Submission from Matthew and Emma Laurence, 1a Battery Street, Clovelly 2031, in response to application No SSD 8126 Redevelopment of Cliffbrook Campus, 41-25 Beach St, Coogee

Section A

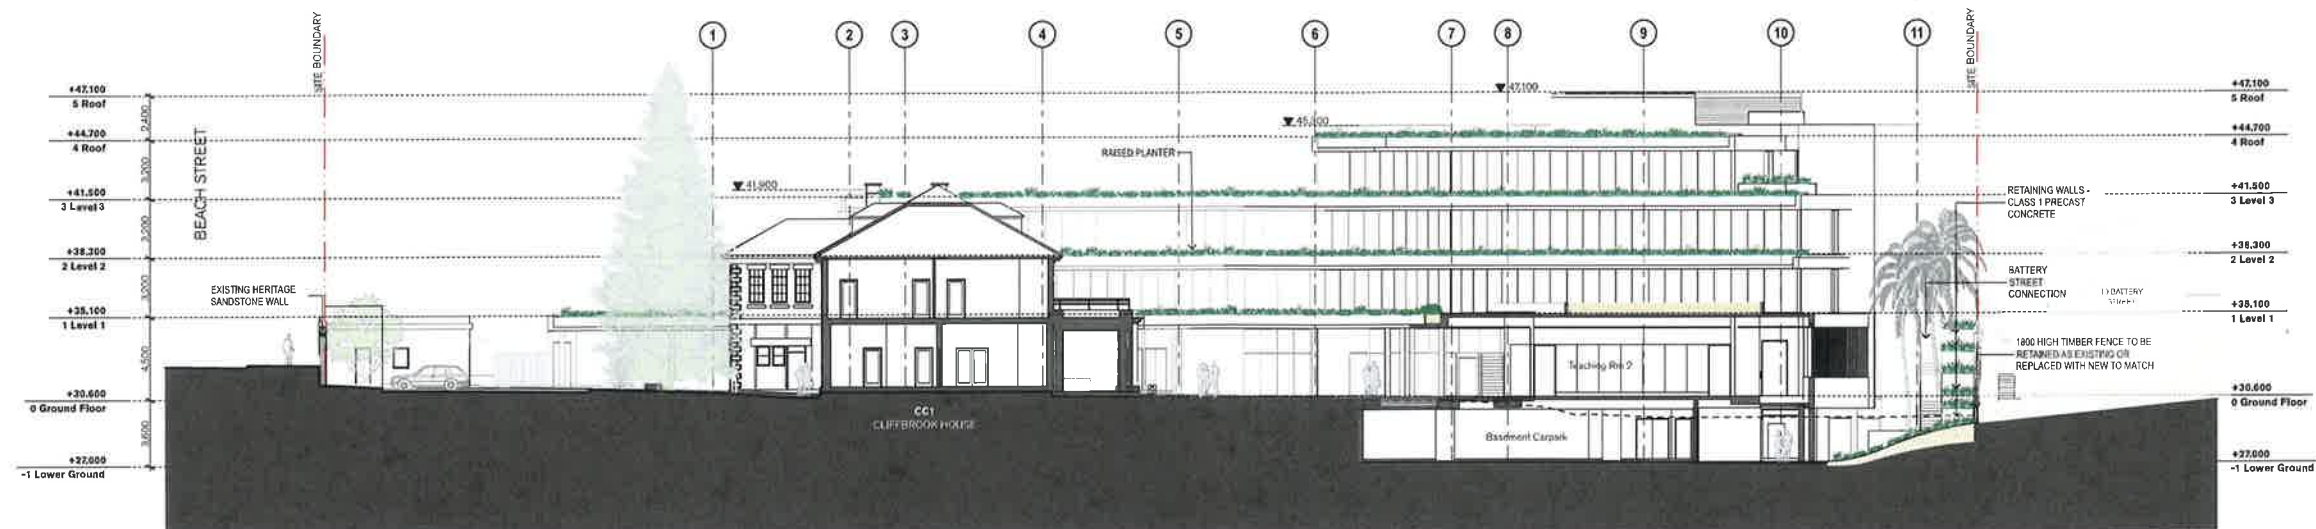
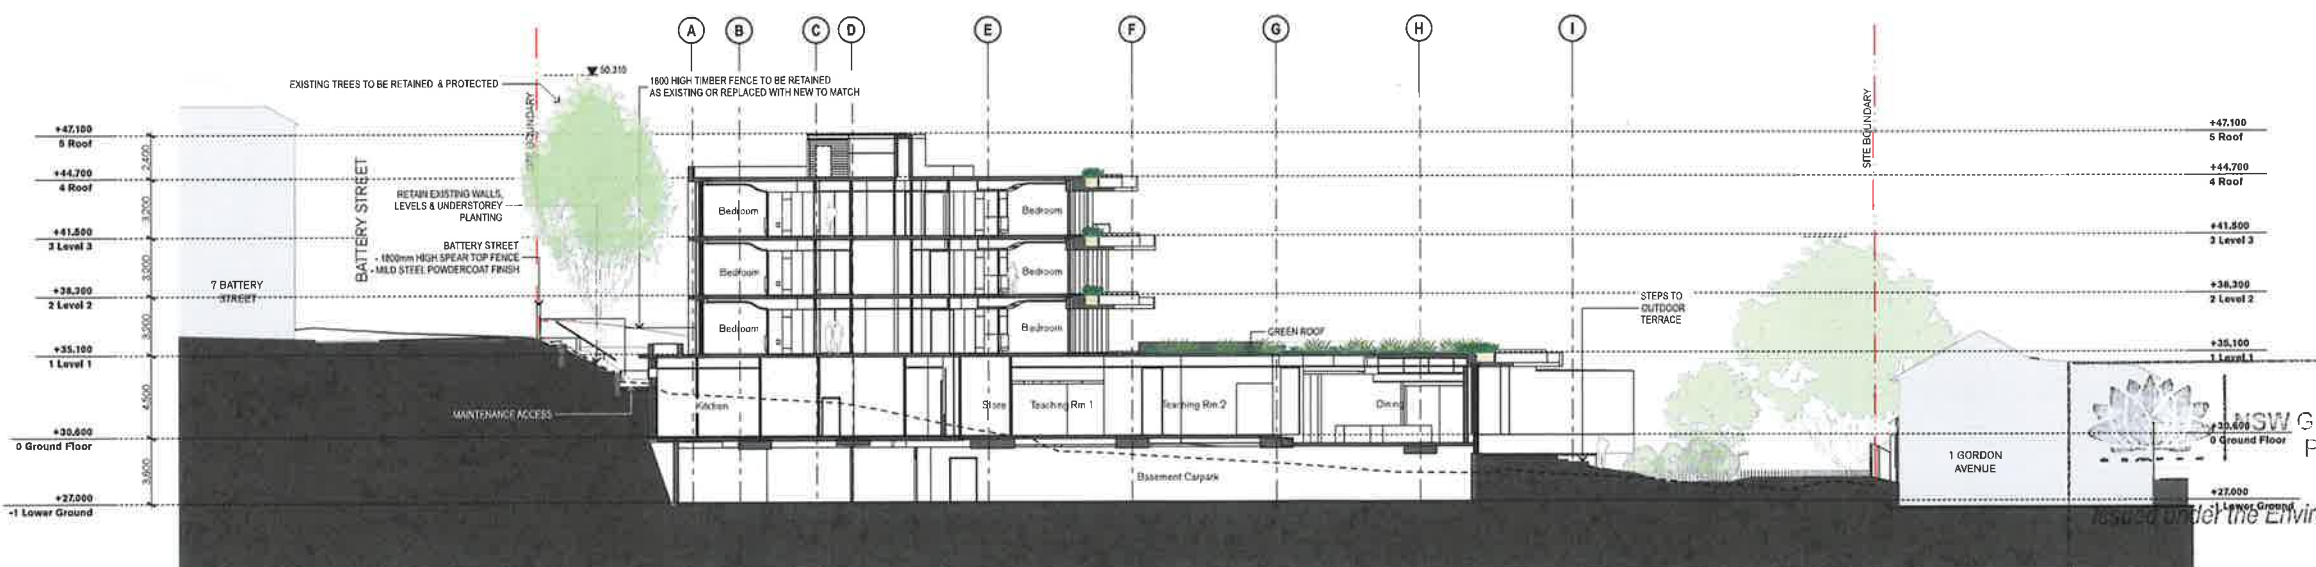
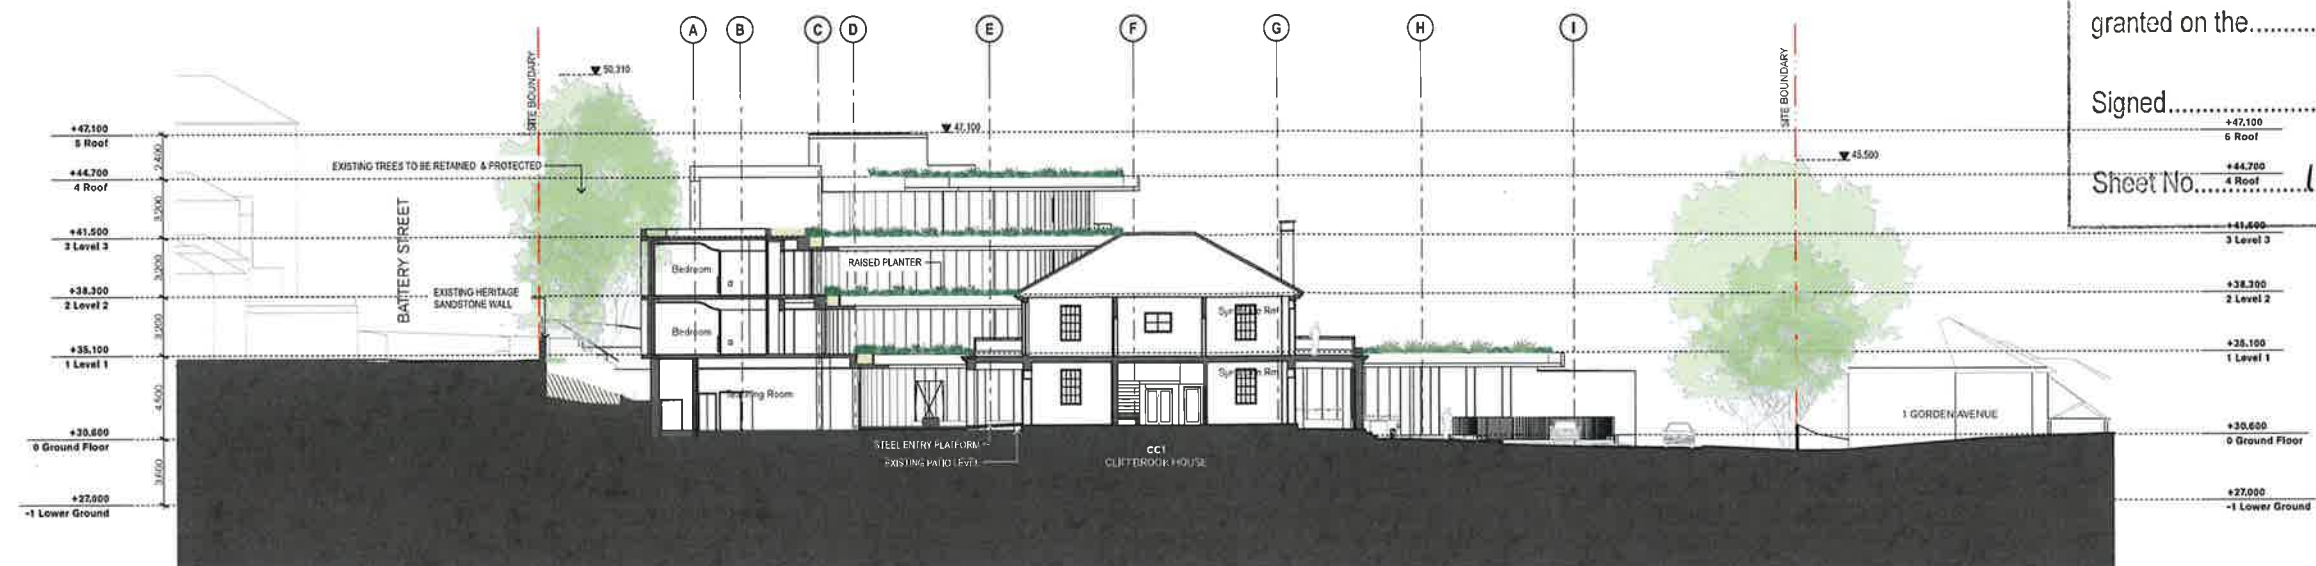
5. Palisade fencing. (Appendix A1_4100 Section A, B, C)

The architectural elements suggested for the building are very sympathetic to the natural landscape and coastal surroundings. However, specifying palisade fencing seems incongruous to the design. Maximising and adding to the existing green screening and complementing it with timber fencing would be preferred, as is the current situation.
